Application number: 2026/90446	
What is the application for?:	Change of use and alterations to convert from retail to micro bar (sui generis)
Address of the site or building:	Denby Dale News, 337-339, Wakefield Road, Denby Dale, Huddersfield, HD8 8RT
Postcode:	S75 6AU

Type of comment: An objection	
Do you wish your comments to be published on the website anonymously?	Yes

Planning Application 2026/90446.

UPPER GROUND FLOOR

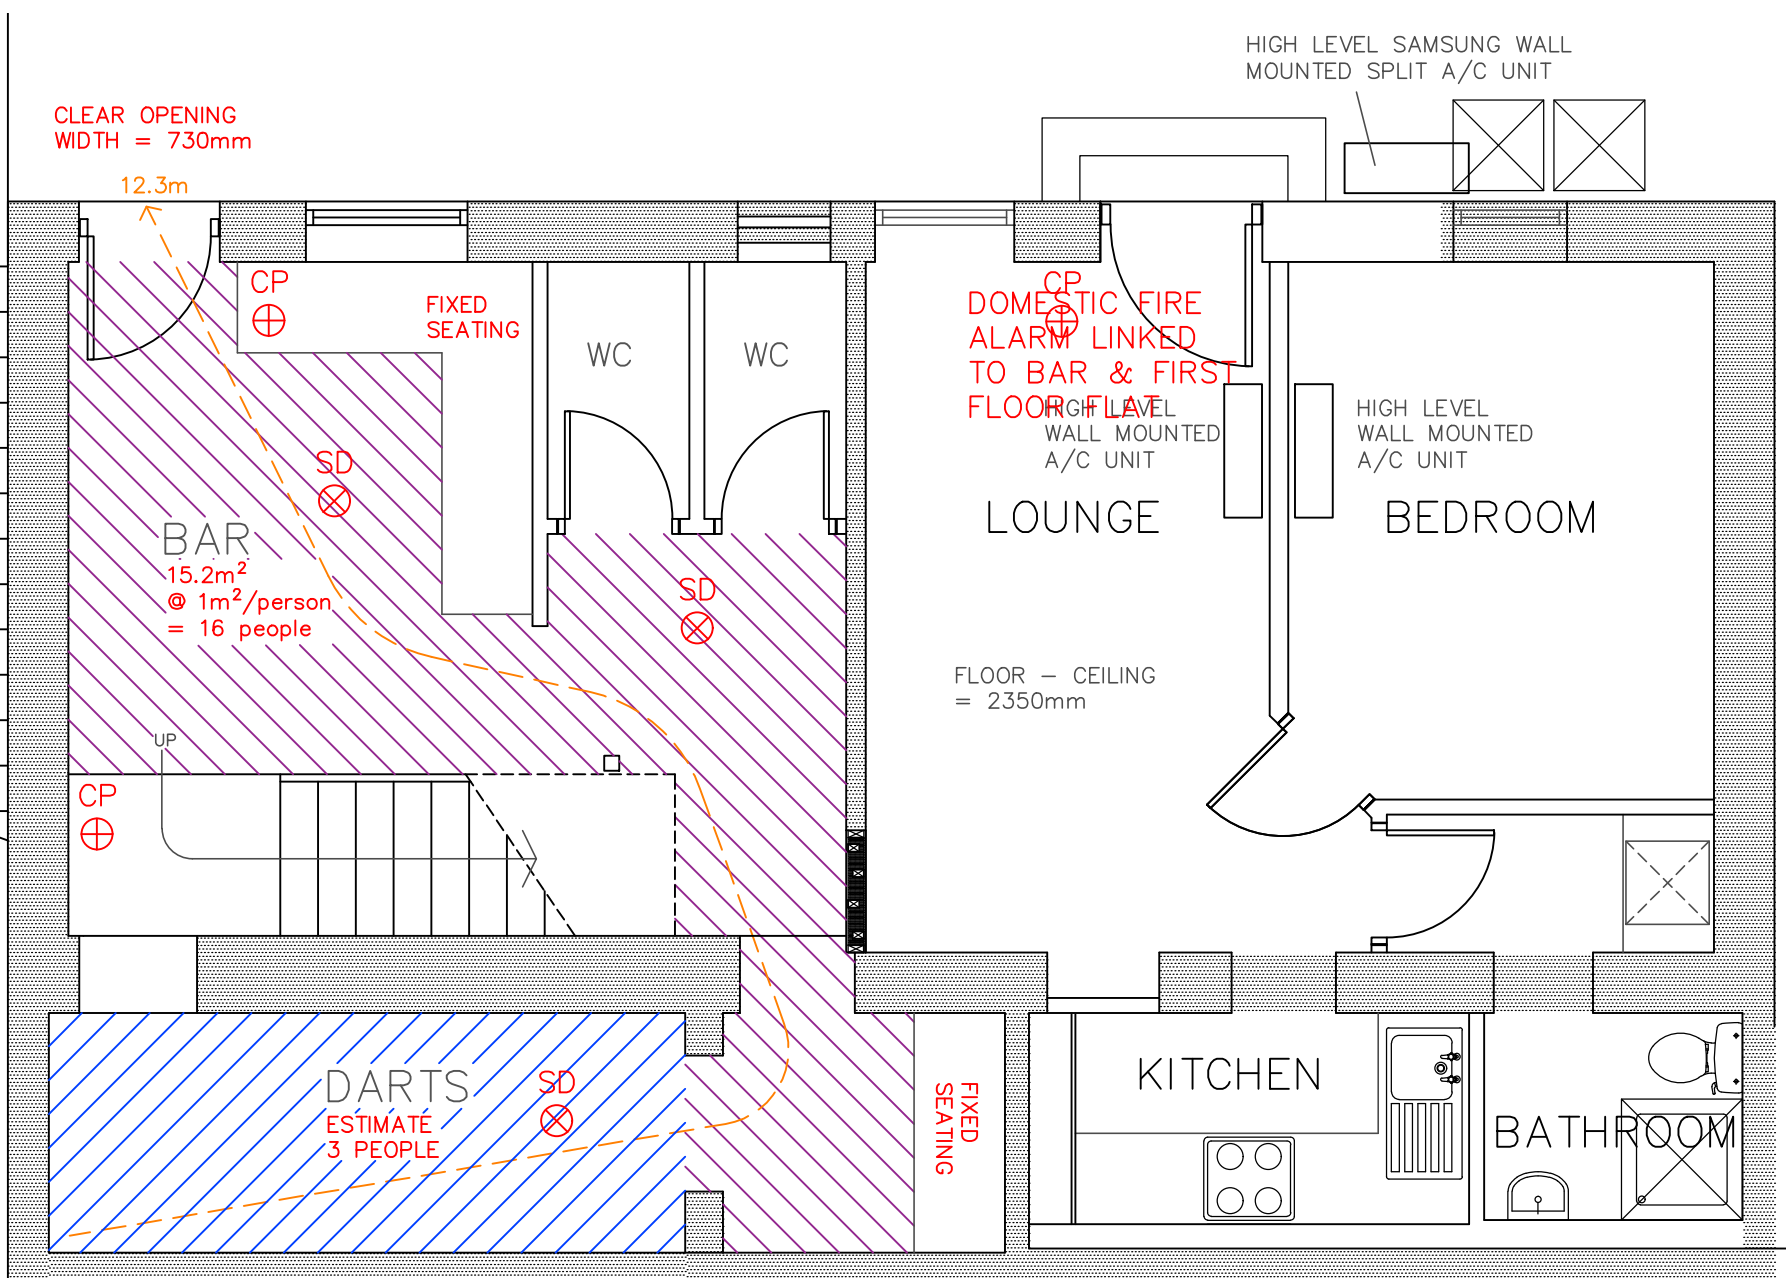
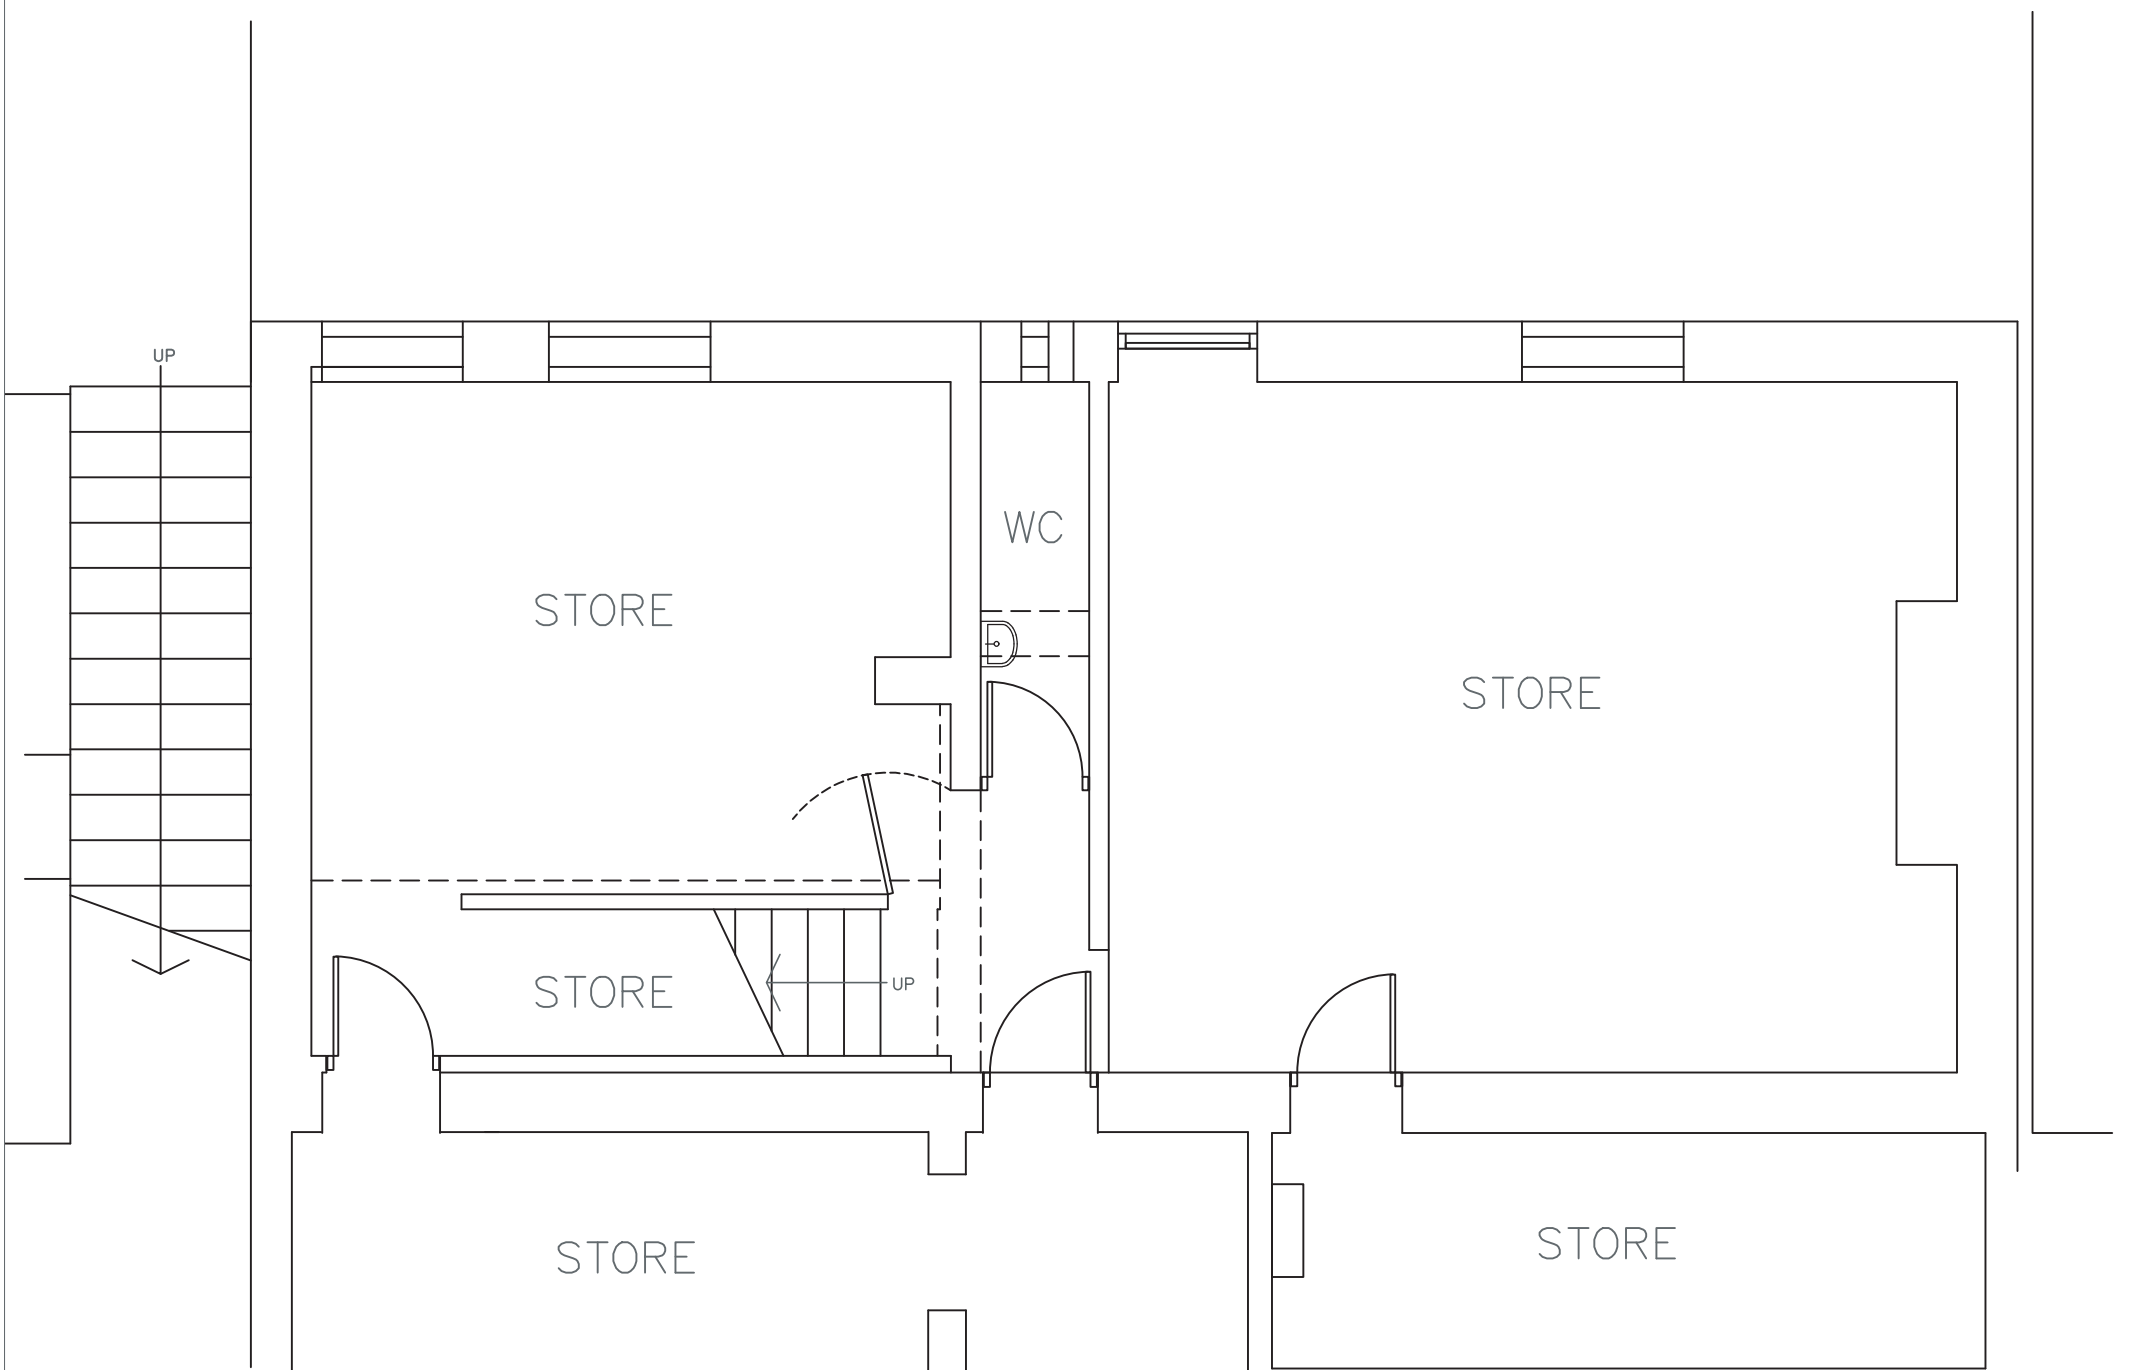
We wish to oppose some of the plans outlined in the application referenced above. As these premises have been trading for over 15 months some of the applicant provided information has inconsistencies. Regarding the floor plans ID 1127750 a small window to the upper floor and glass doors on the lower level have already had brickwork removed and been installed. The garden photo ID1127751 is of the garden after renovation. The plan of the rear beer garden marks a green area presumably notifying vegetation. This area is actually a metre wide strip of unowned land where the applicant has stored a large amount of rubbish. He was informed at the licensing hearing it was not land owned by 337-339 Wakefield Road. The outbuilding marked on the same plan has had all the vegetation removed from the roof. The asbestos roof is now exposed and crumbling into the ground between properties and the applicants.

We would also highlight the external steps at the side of the property presumably used as patrons access & also as a fire exit. These steps are neither very wide or safe. The applicant has omitted when saying the Environmental Health had no issues with the front exterior of the property being used. The Environmental Health would oppose any plans to use the rear of the property as a beer garden. This was for various reasons & would state these again at the planning application stage.
